Ribble Valley Borough Council
Housing & Development Control

Application no: **3/2023/0190**

Address: **Waddington Arms Clitheroe Road Waddington BB7 3HP and 58 West View Clitheroe Road Waddington BB7 3HP**

Proposal: **Demolition of existing rear outriggers and replacement with new two storey rear extension to provide new kitchen, cellar, additional dining space, refuse storage and additional first floor bedrooms. Insertion of five new rooflights to front elevation.**

name
site plan with parking

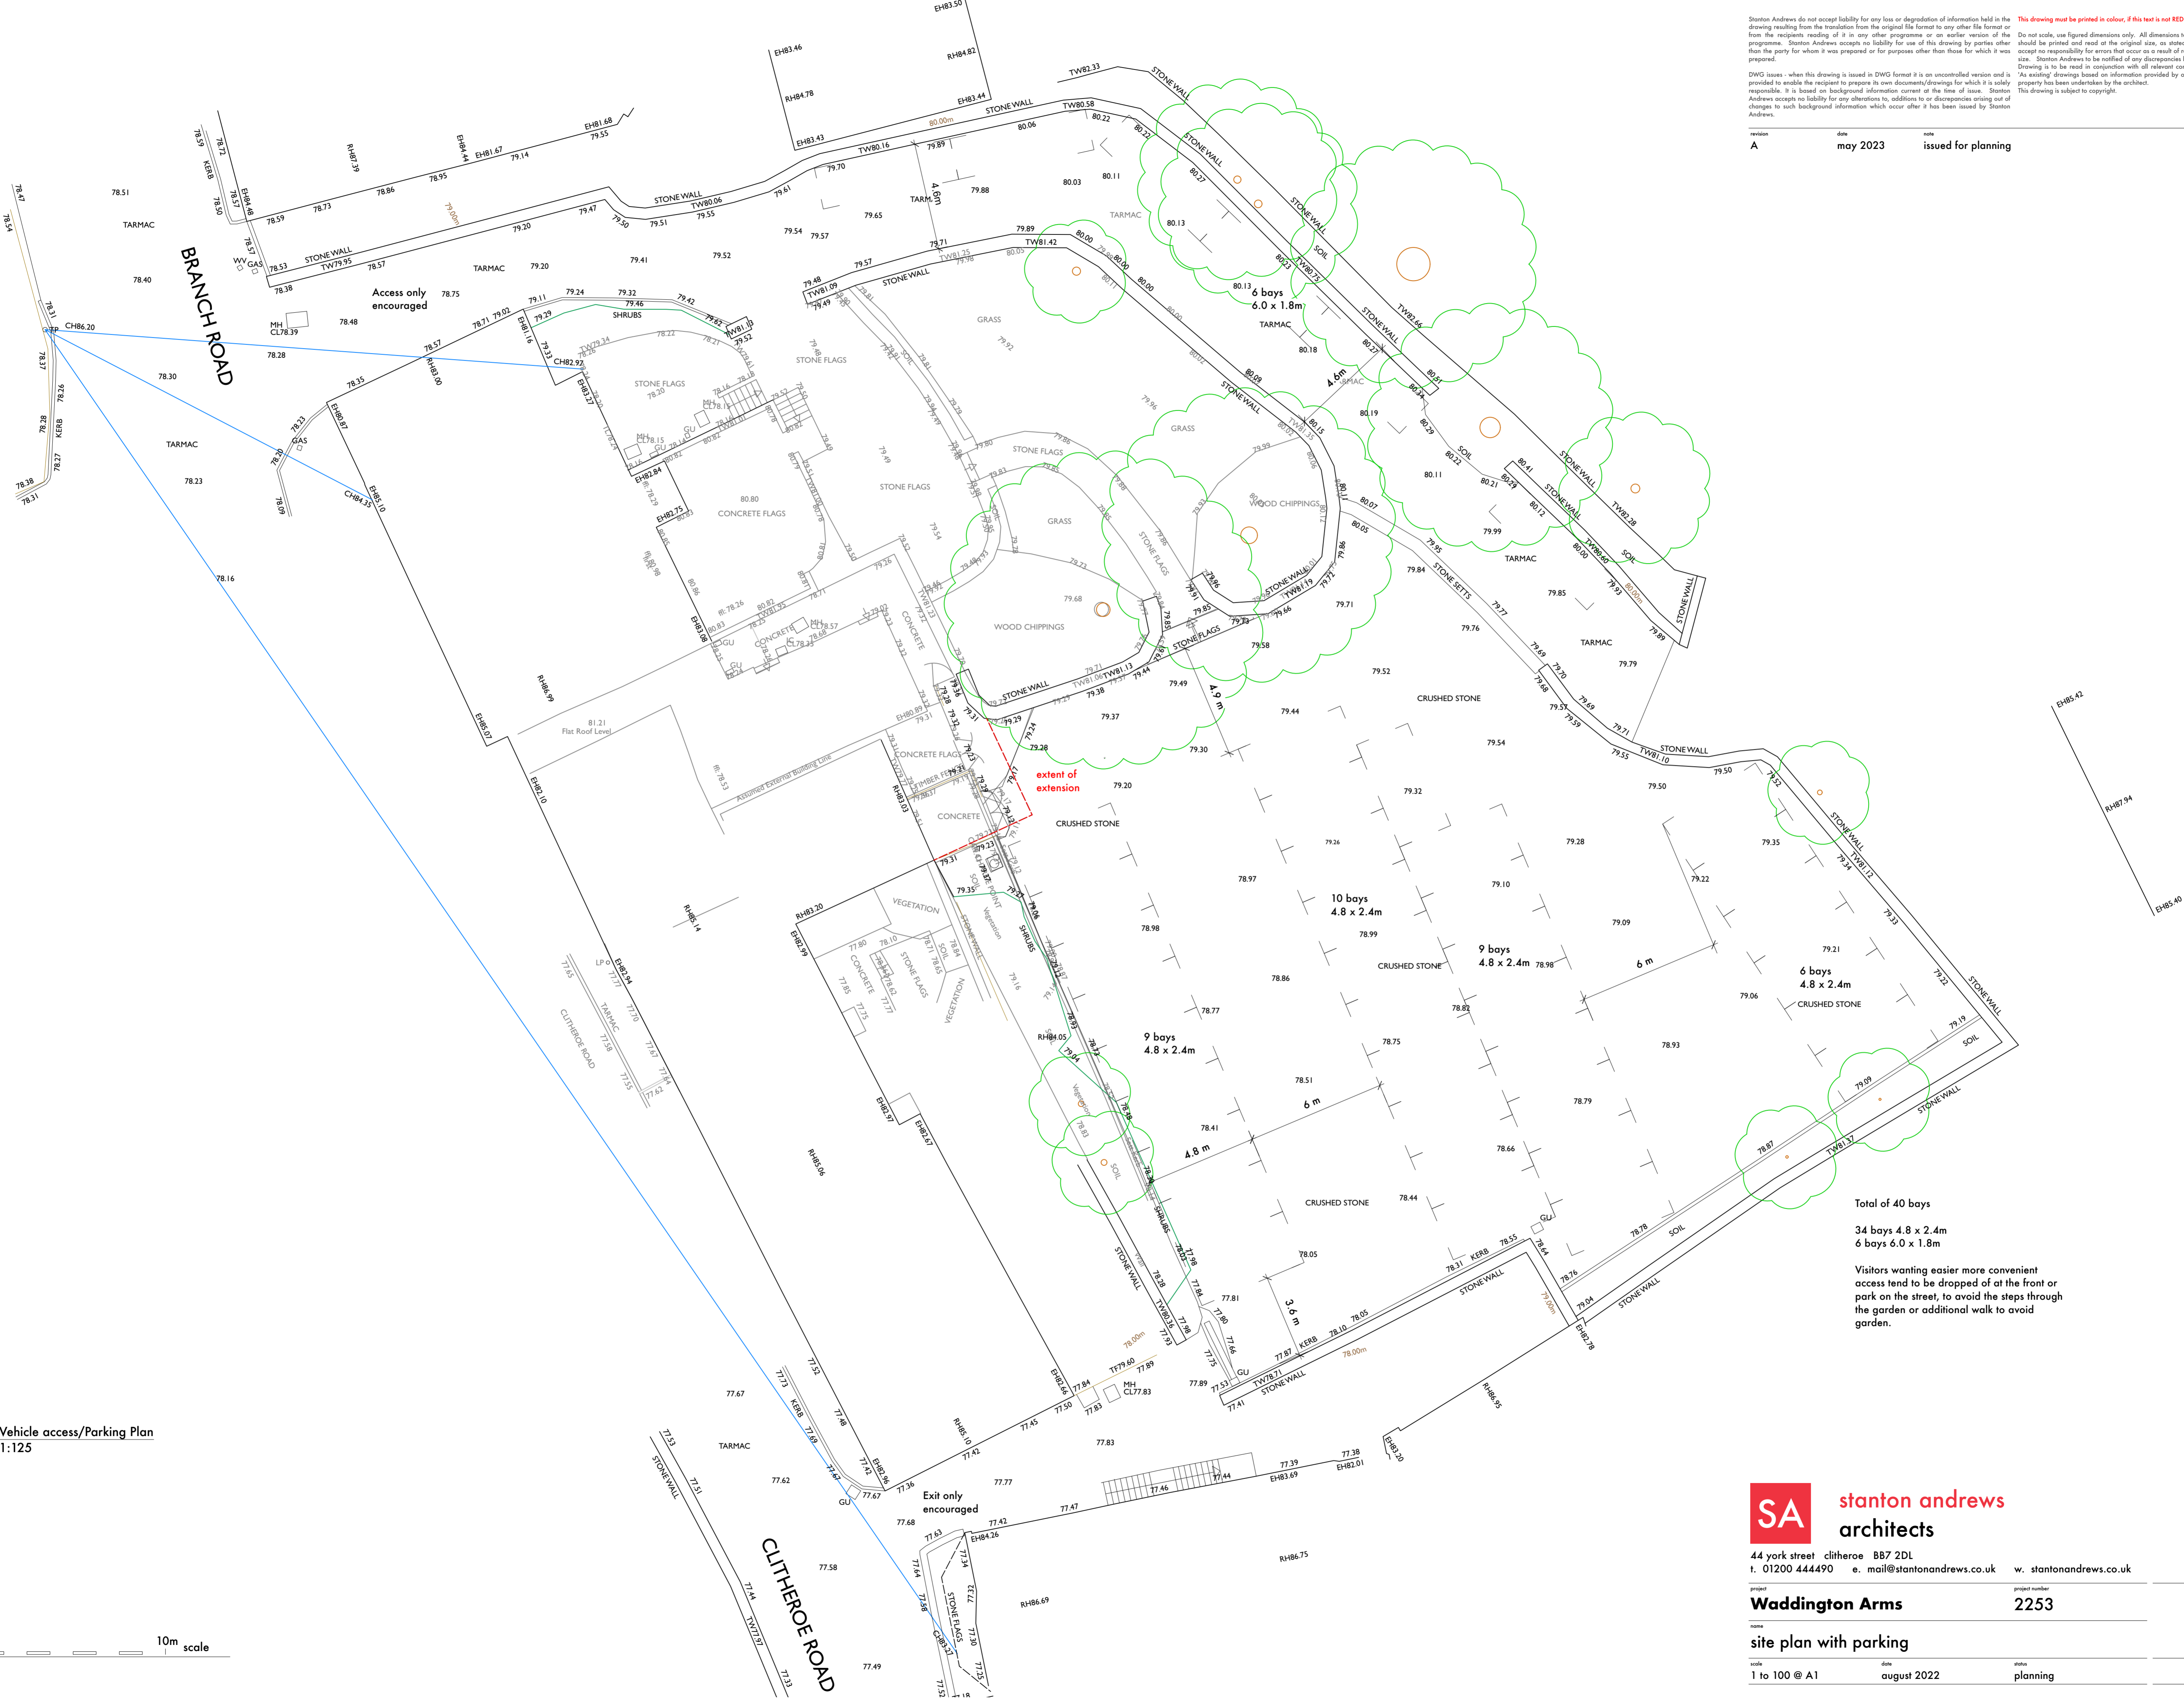
The LHA have reviewed Stanton Andrews drawing number PL.00 Rev A titled "Site Plan with Parking" and are aware that the site has access to two accesses. One of the accesses is located off Branch Road while the other is located off Clitheroe Road, a B classified road subject to a 30mph speed limit.

The LHA have reviewed Stanton Andrews drawing number PL.00 Rev A titled "Site Plan with Parking" and are aware that the main car park can provide 34 car parking spaces should the area become formalised and 6 informal parallel bays are provided around the access track into the car park to serve the proposal. Therefore, the site has a total of 40 car parking spaces.

The parking study found that the maximum number of vehicles parked at the site was 26 and this was at 8pm. Therefore, the site had 14 car parking spaces free, before the car park reached full capacity.

The LHA are aware that Friday nights at any Public House and restaurant are likely to be one of the busiest days of the week and so the parking study provides a fair reflection of the existing car parking demand at the site. Therefore, while the LHA require an additional 17 car parking spaces for the proposal to comply with the LHAs parking guidance, as defined in the Joint Lancashire Structure Plan, the LHA are satisfied that the car park has adequate capacity to cater for the greater demand for car parking spaces at the site, given the amount of spare capacity found at the site during the study.

As a result, the LHA have no objection to the proposal but will request that the car park is adequately surfaced and marked out into parking bays to maximise the space available.

1. Prior to completion, the car parking area is required to be adequately surfaced or paved in accordance with a scheme to be approved by the Local Planning Authority and the car parking spaces and manoeuvring areas marked out in accordance with Stanton Andrews drawing number PL.00 Rev A. The car parking area shall thereafter be always kept free of obstruction and available for the parking of cars.
